WHALLEY PARISH COUNCIL

Planning Application No: 3/2023/0327

Proposal: Outline application for the erection of a detached dwelling with access applied for (all other matters reserved).

Location: 19 Abbey Road Whalley BB7 9RP

Proposed Site Plan - Scale 1:100

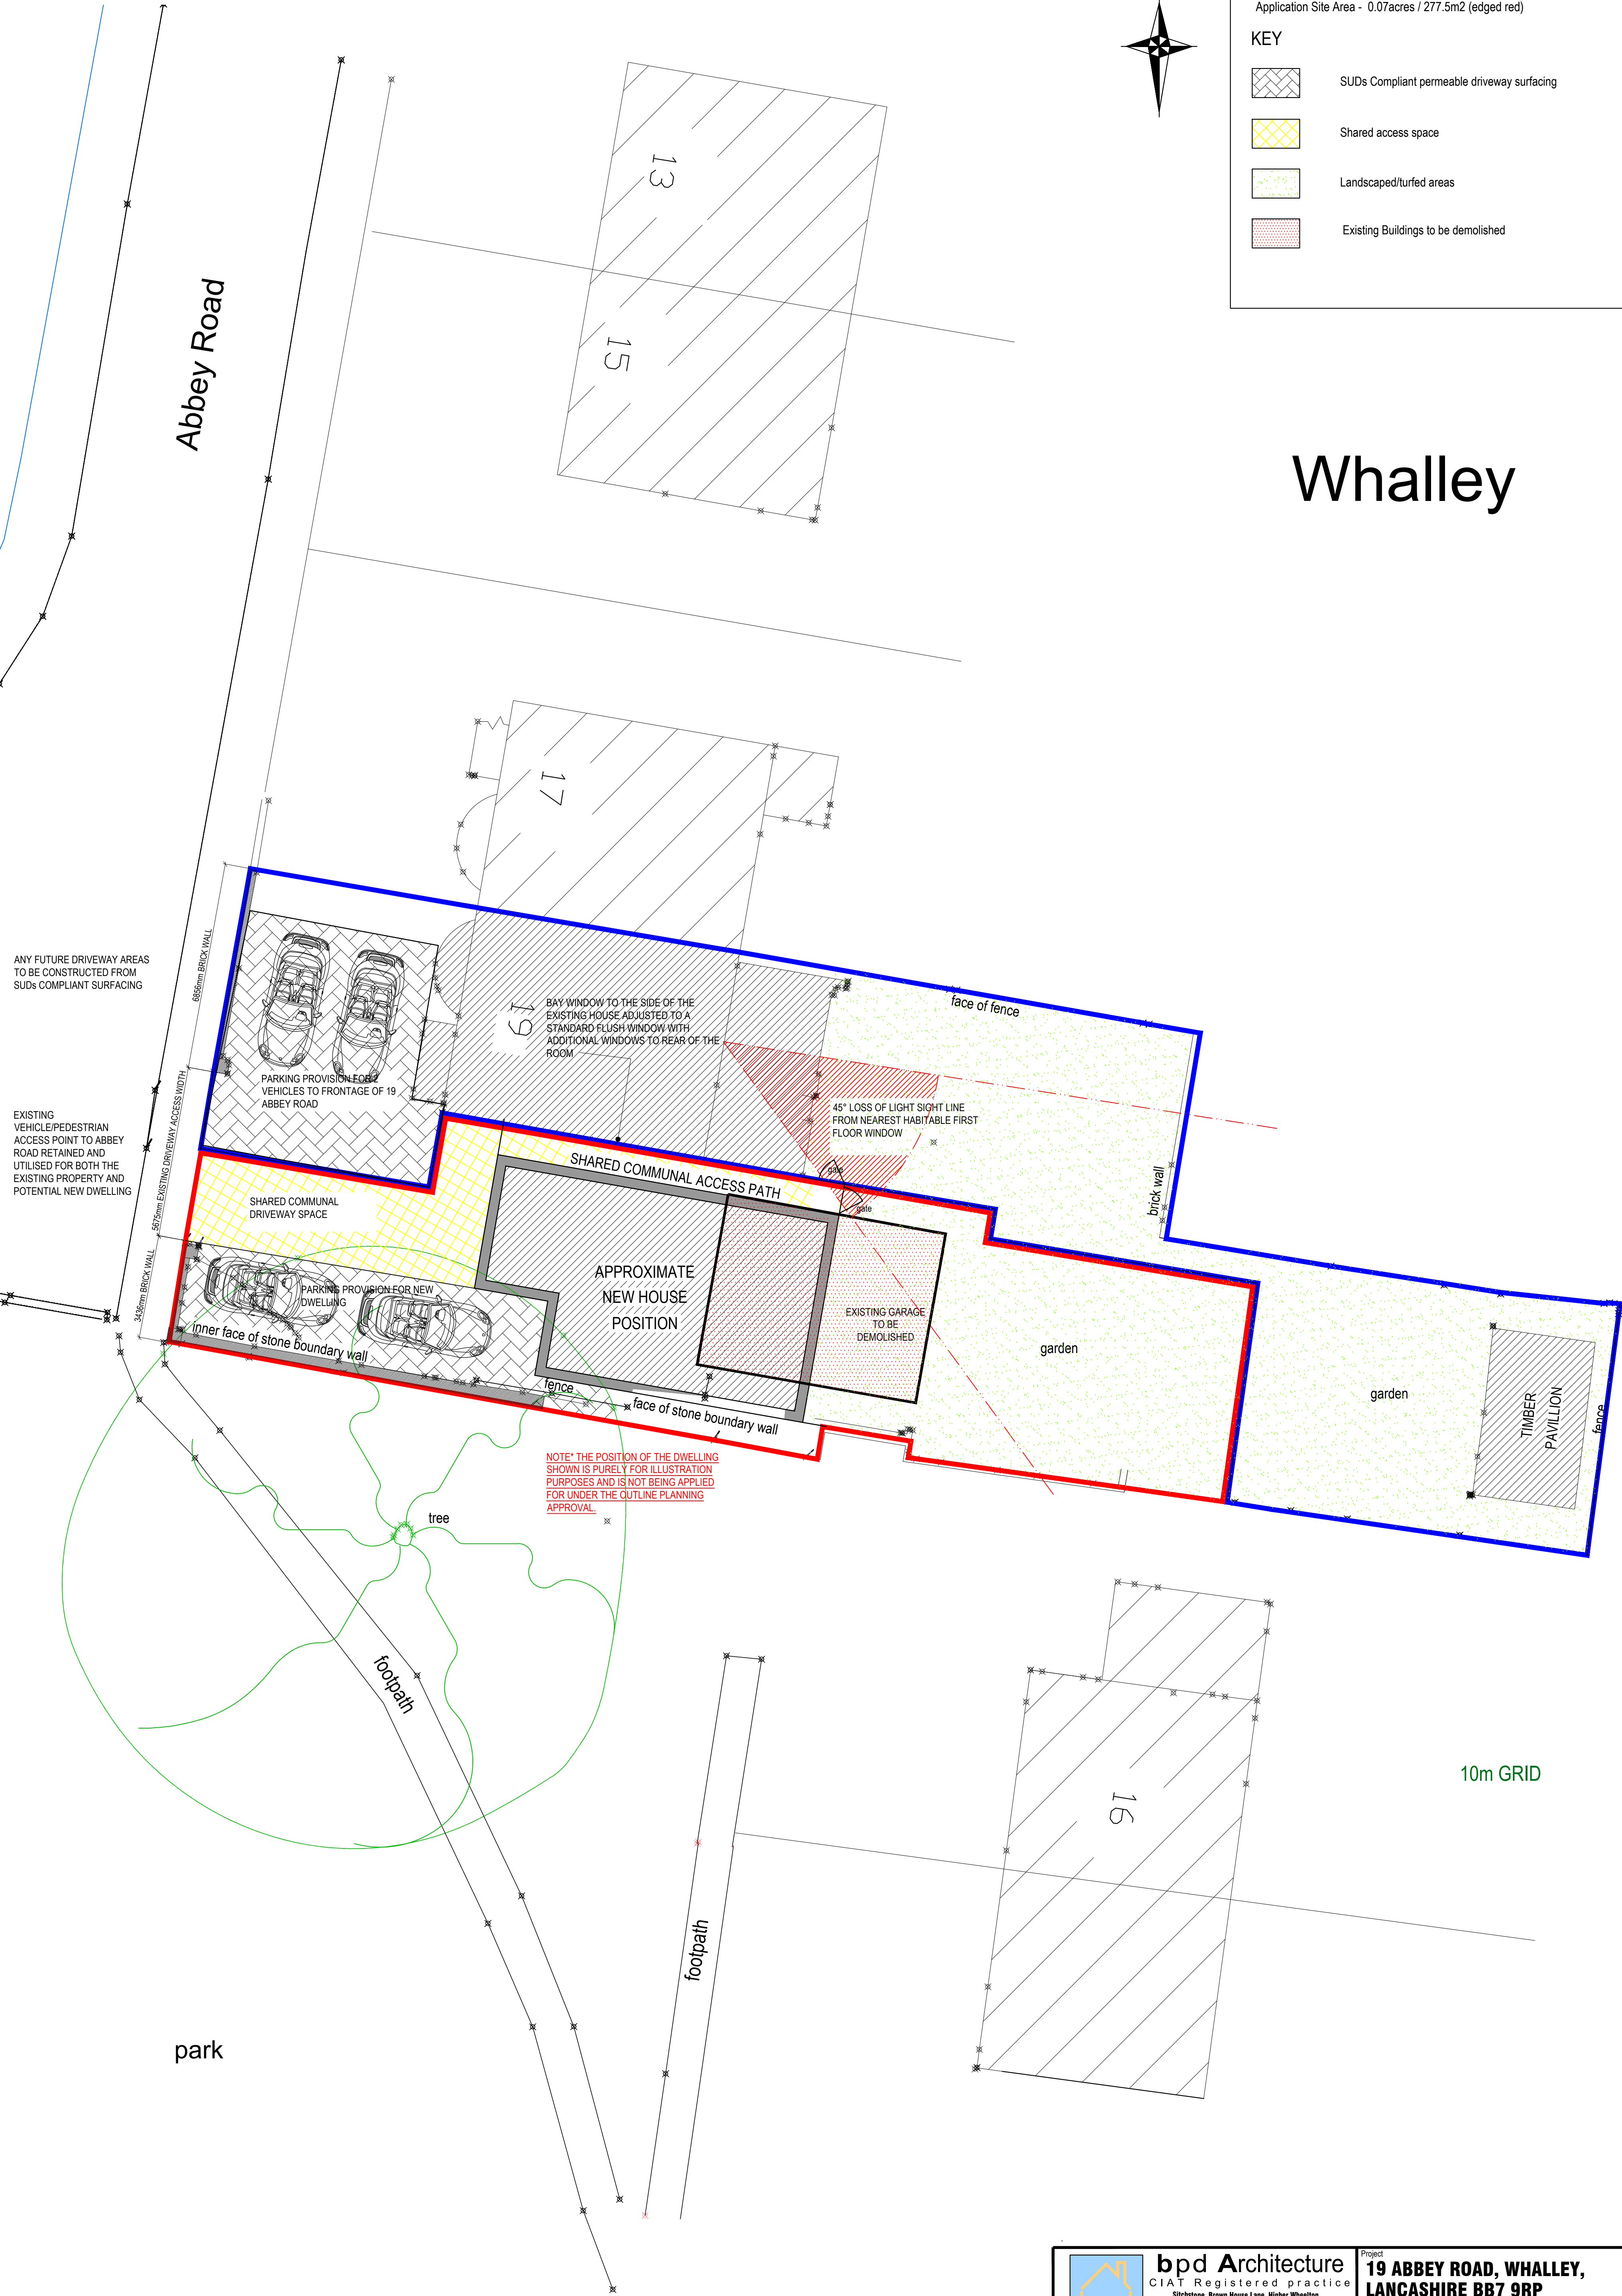
Whalley Parish Council would like to comment that the detached dwelling is too large for the proposed site location and is not in keeping with the character of this conservation area.
